**APPLICATION BY KEADBY NEXT GENERATION LIMITED FOR AN ORDER GRANTING DEVELOPMENT CONSENT FOR THE KEADBY NEXT GENERATION POWER STATION PROJECT**

**SCHEDULE OF AMENDMENTS FOLLOWING S.51 ADVICE**

60721867

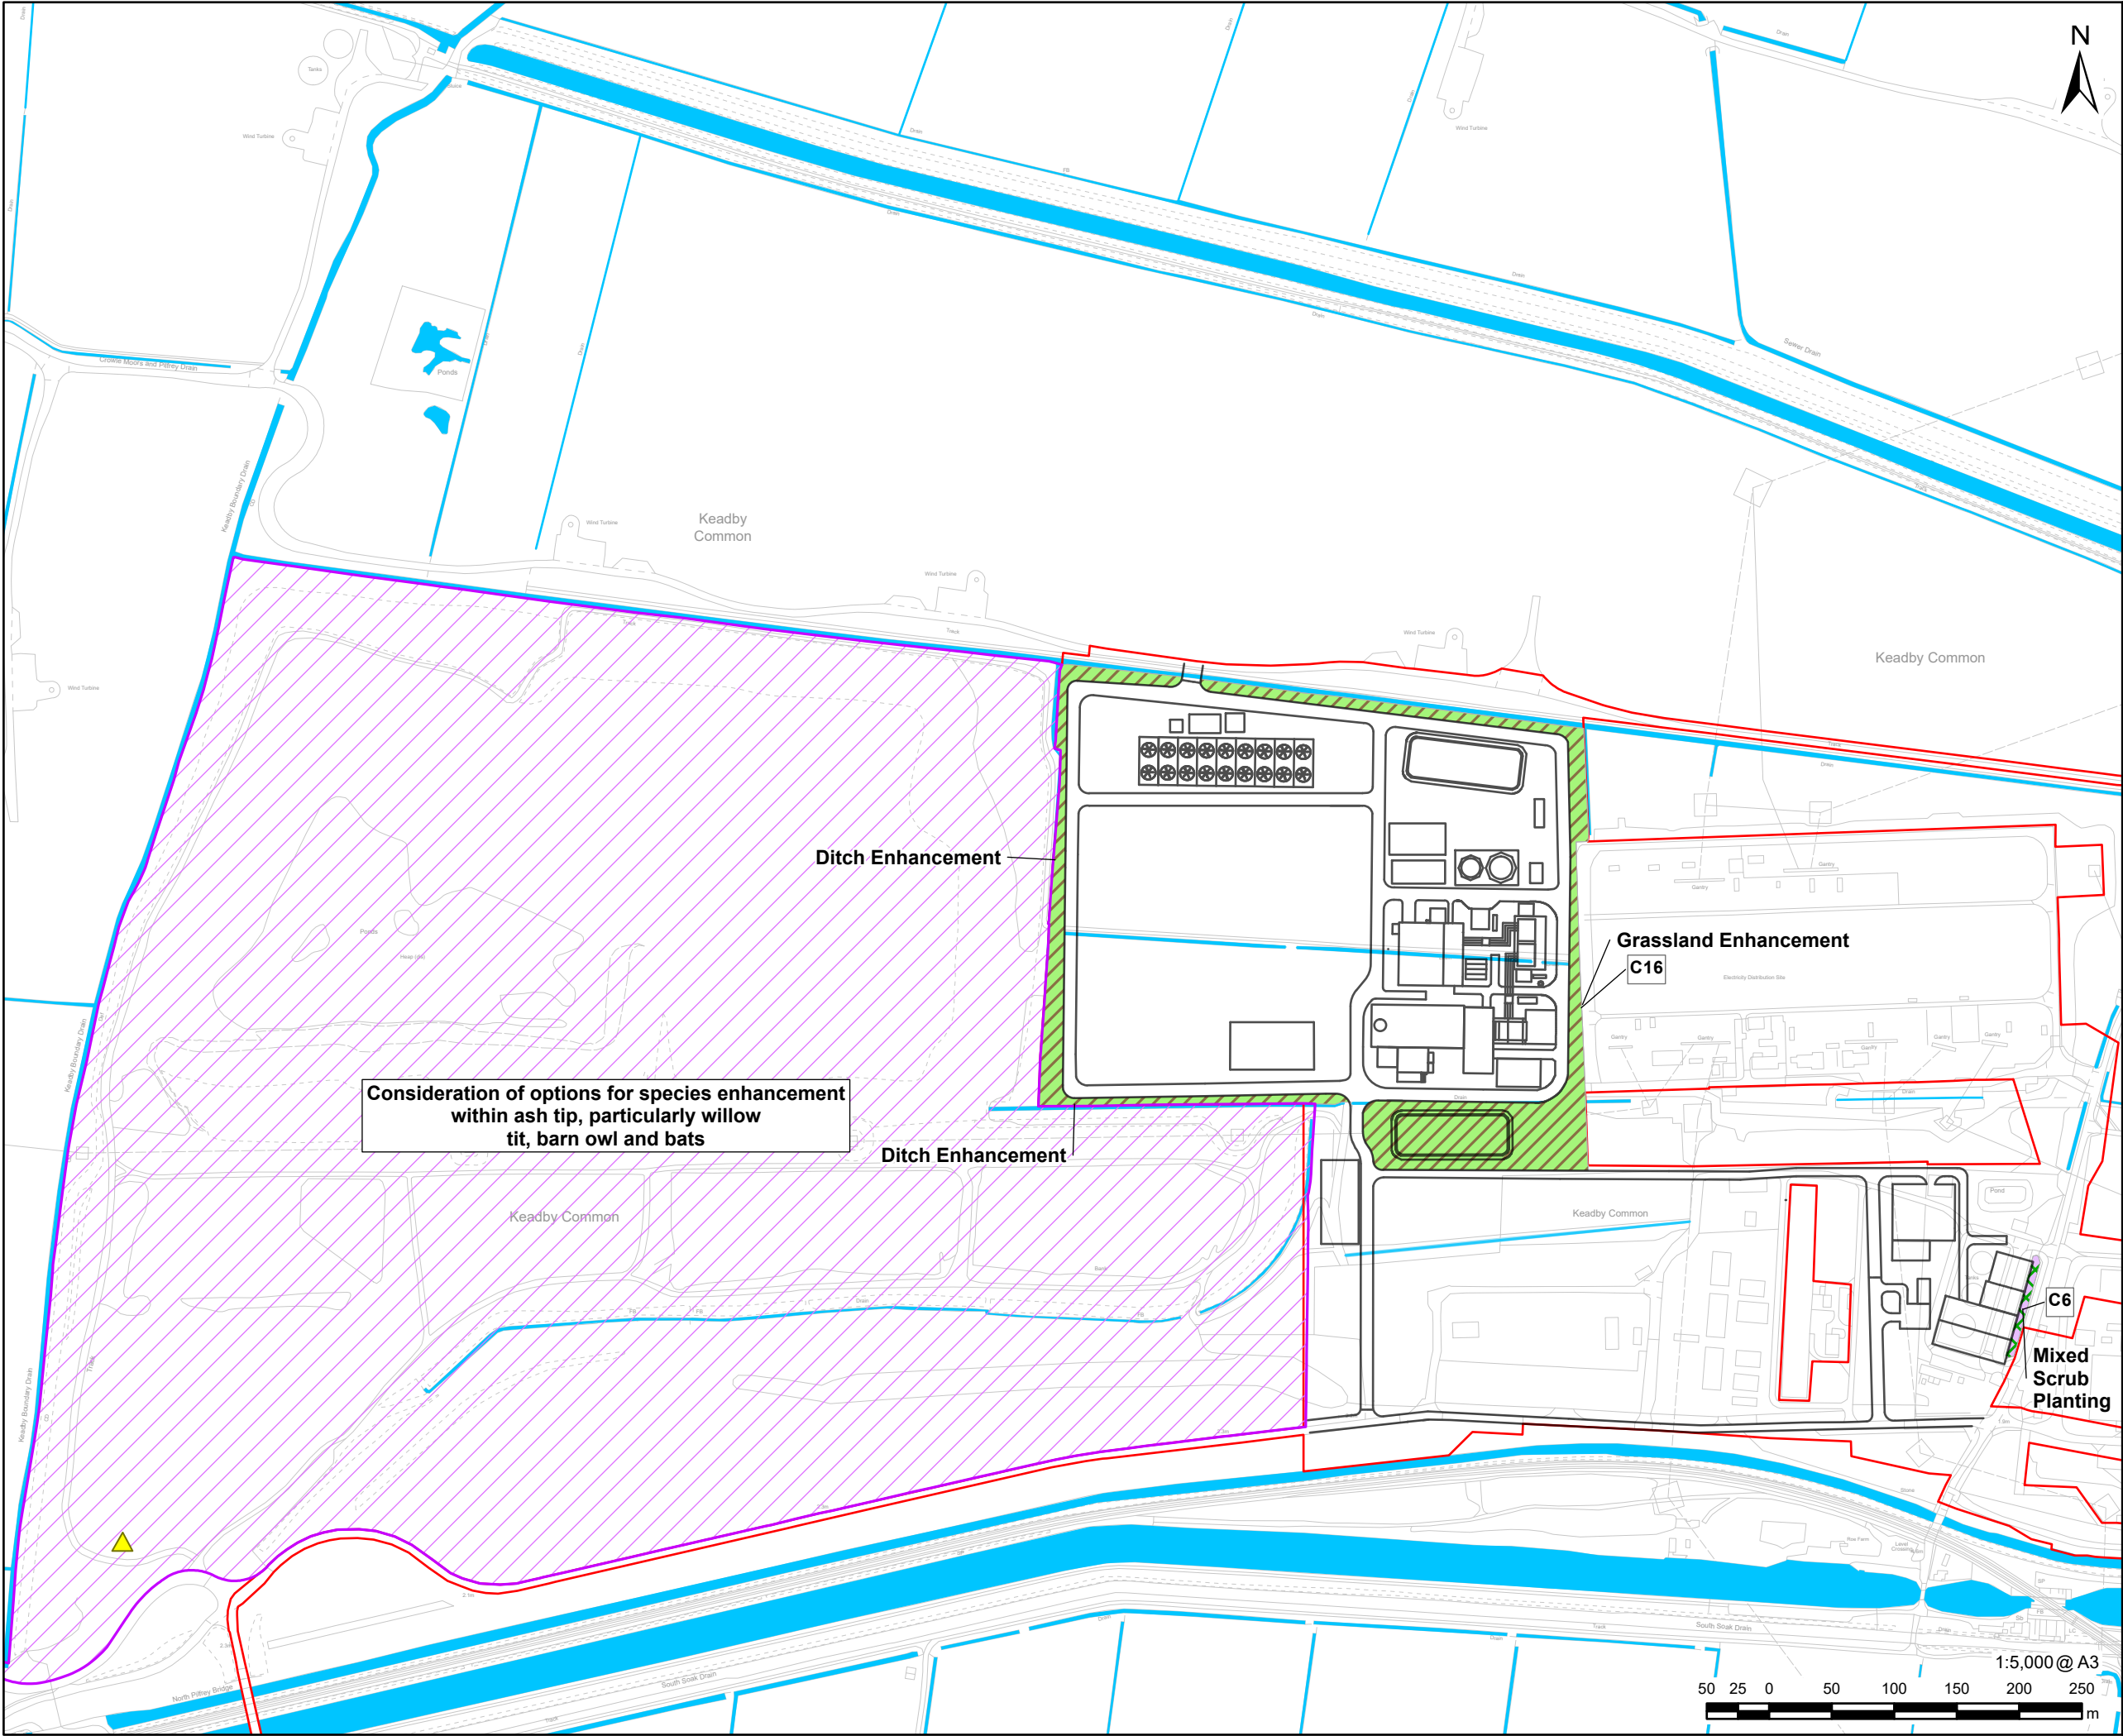
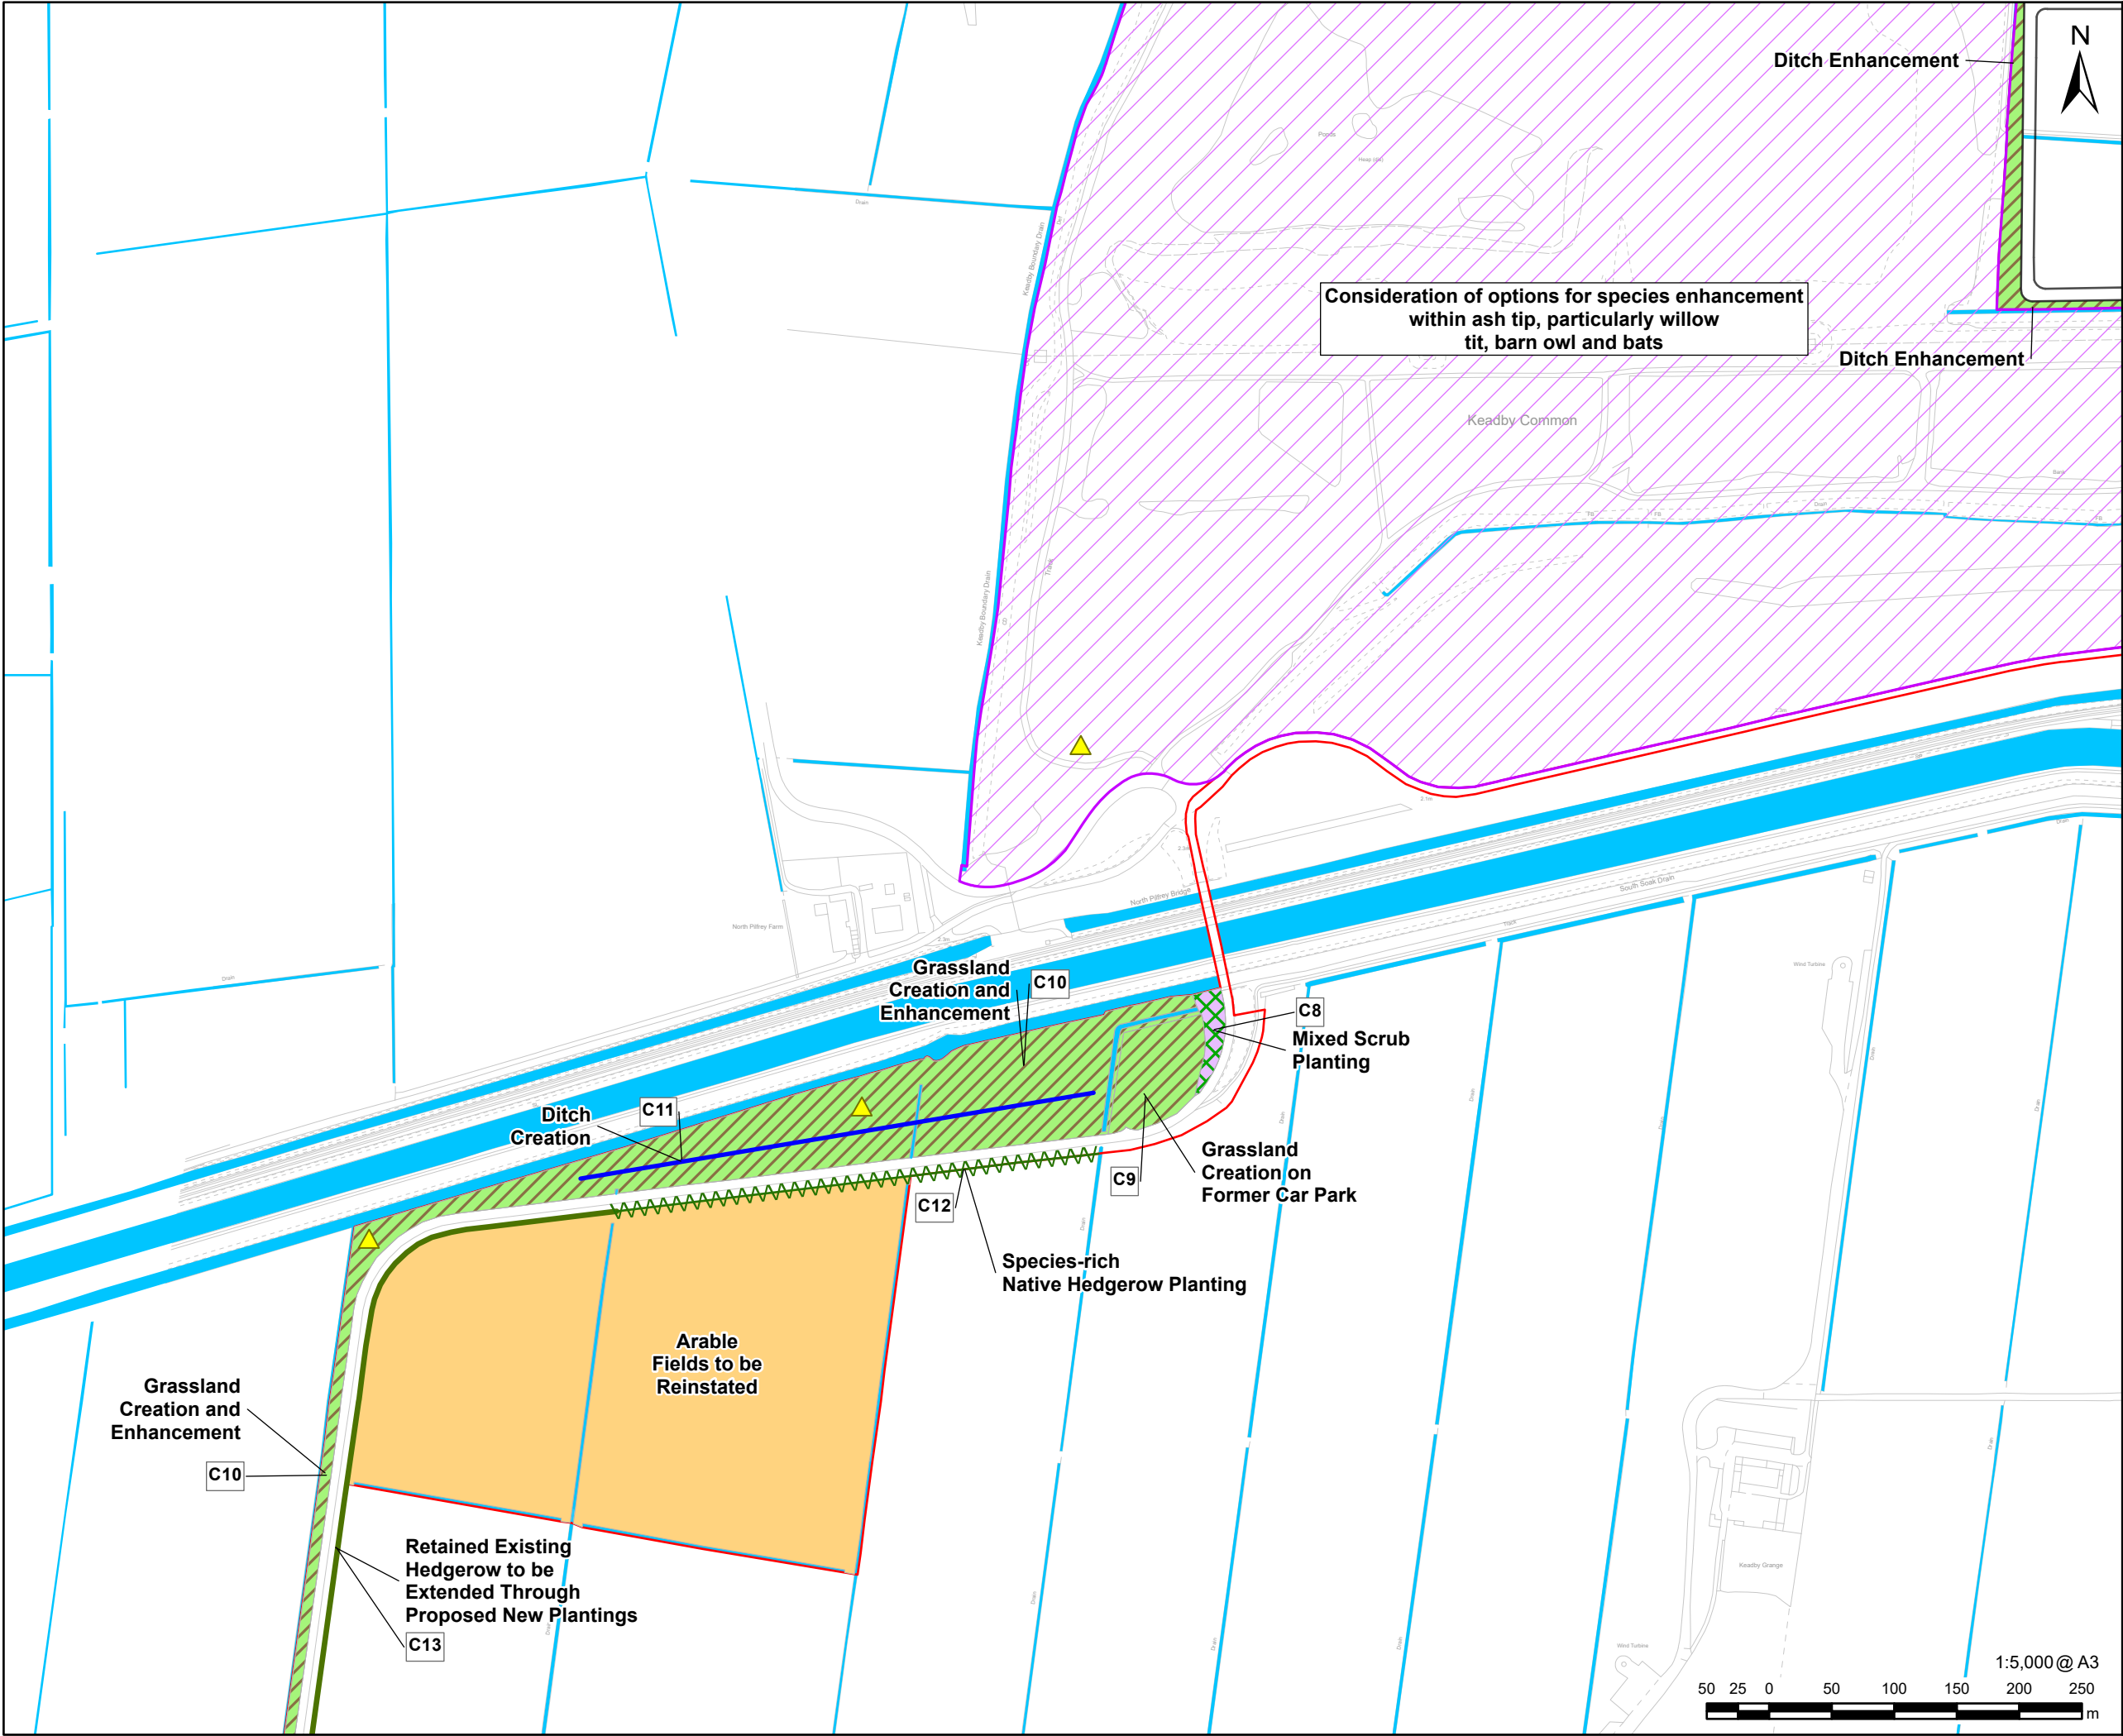
Issue	Detail	Response
Indicative Landscape and Biodiversity Plan (Doc 2.18)	Missing a key plan	Key Plan added – see Indicative Landscape and Biodiversity Plan Rev 1.
Draft Development Consent Order (dDCO) (Doc 3.1)	Query as to why a Deemed Marine Licence (DML) included in K3 but not for KNGPS.	<p>No works are proposed within the marine area, as part of the water discharge corridor that requires a DML to be in place for the purposes of constructing the Proposed Development.</p> <p>As noted in the s.51 letter of 22 September 2025, no river water abstraction option is proposed as part of this Application. The Application includes Work No.6 which is similar in scope to Work No. 5 of the Keadby 3 consent. These works include:</p> <p>i) connection works to an existing pipeline, which will occur on land (the Connection Works),</p> <p>ii) potential upgrades to an existing pipeline and associated structures (the Upgrade Works).</p> <p>Discharge from the existing pipeline would be regulated by the environmental permitting regime, and not the marine licensing regime. Therefore, no marine licence is required in this regard.</p> <p>Since the Connection Works will occur on land, they are not within the ‘marine area’ and therefore do not fall under the MMO's jurisdiction and therefore do not require a marine licence.</p> <p>The Upgrade Works have been included within Schedule 1 of the draft DCO to ensure that the Applicant has the ability to upgrade and replace the outfall structure and connecting pipeline as necessary during the lifetime of the development. These are not works that are required to be undertaken as part of the initial construction stage.</p>
